Our ref: J027707

**Site: Former Wilthorpe Public House, Huddersfield Road, Barnsley, S75 1HA**  
**Planning Application for: Variation of Condition 2 of planning permission 2012/0618**

Scale:	Date:	Drawn:	Checked:
1:100@A1	17.05.12	MED	DJF
Project No:	Drawing No:	Revision:	
4582	(P) 503	C

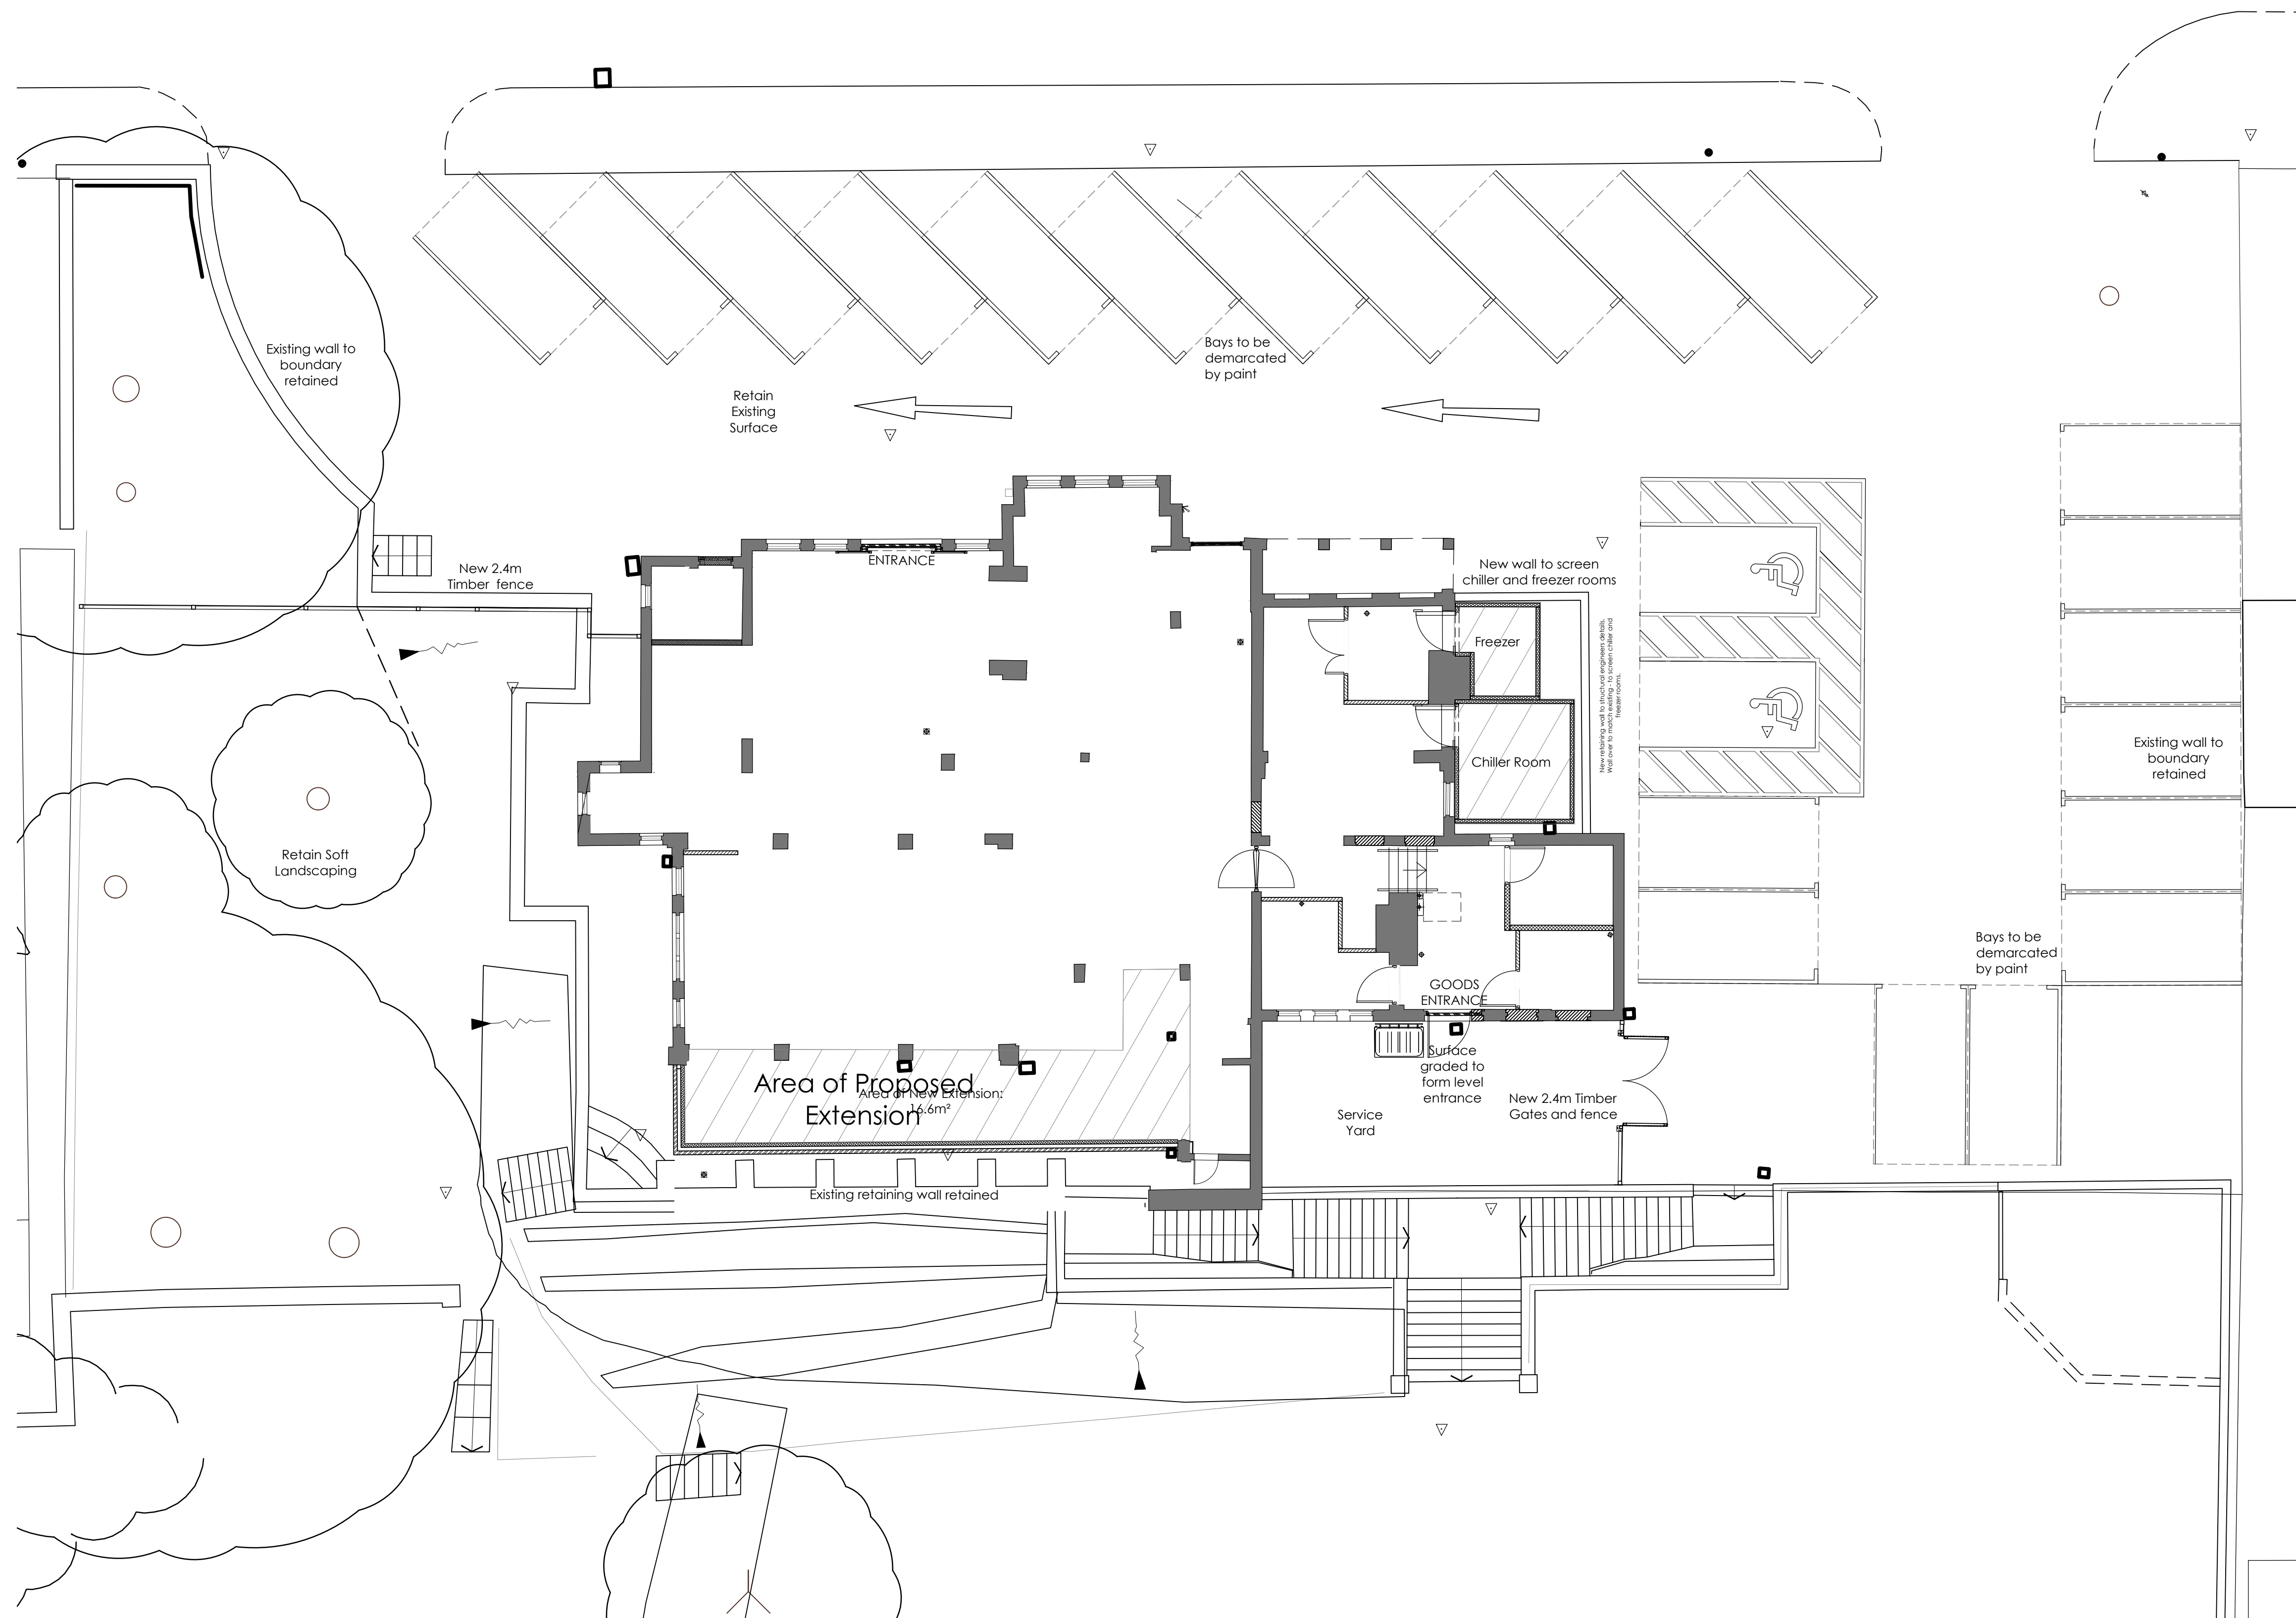
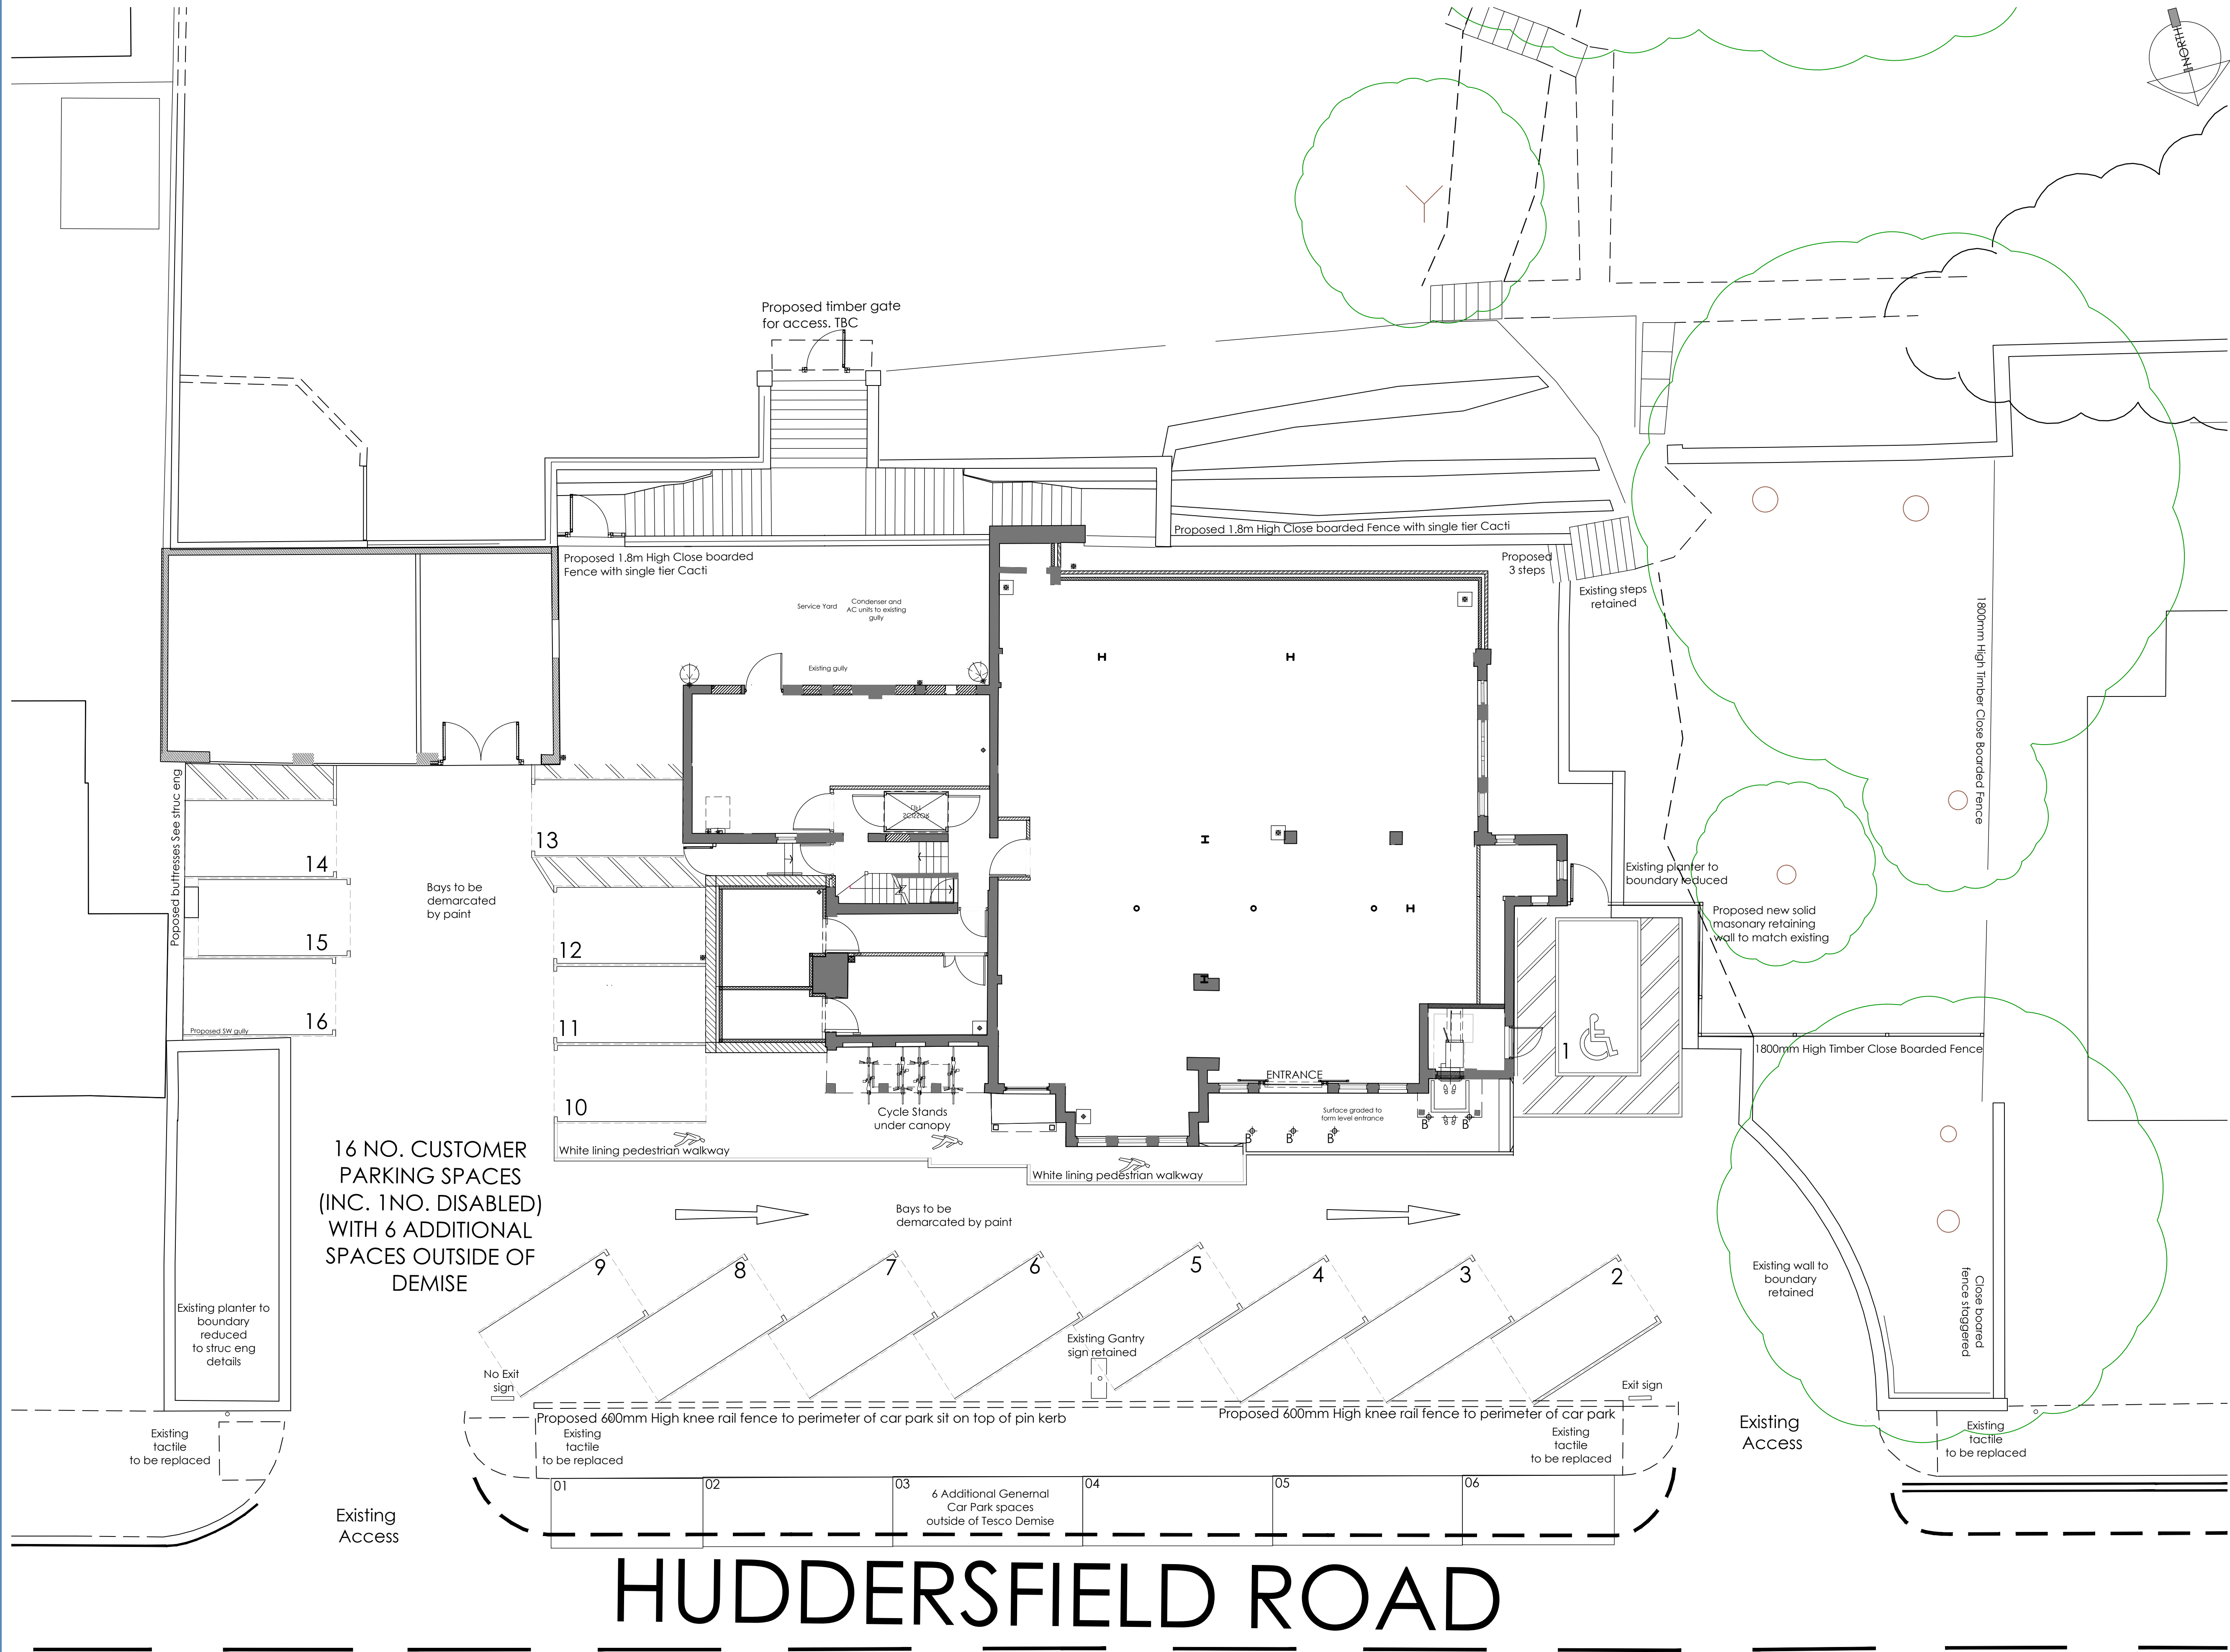
This application has been submitted upon the basis that as a result of a scheme change incorporating the retention of the existing garages to the rear of the site and the subsequent reconfiguration of the car park.

The primary reason for retaining the garages relates to the next door property at 126 Huddersfield Road. Currently the garages are buttressing the walls which are retaining 126 Huddersfield Road's garden and the grassed land to the rear of the site, therefore in removing the garages it would create a considerable restructuring exercise and would significantly disrupt the next door property.

It is important to note that our client will be enhancing the garages by covering and protecting the frontage with close boarded timber. In doing this the garages will be visually enhanced and symmetrical in design and therefore will not be visually intrusive within the car park.

*"The development hereby approved shall be carried out strictly in accordance with the plans (Nos (P)203, (P)503 RevC) and specifications as approved unless required by any other conditions in this permission."*
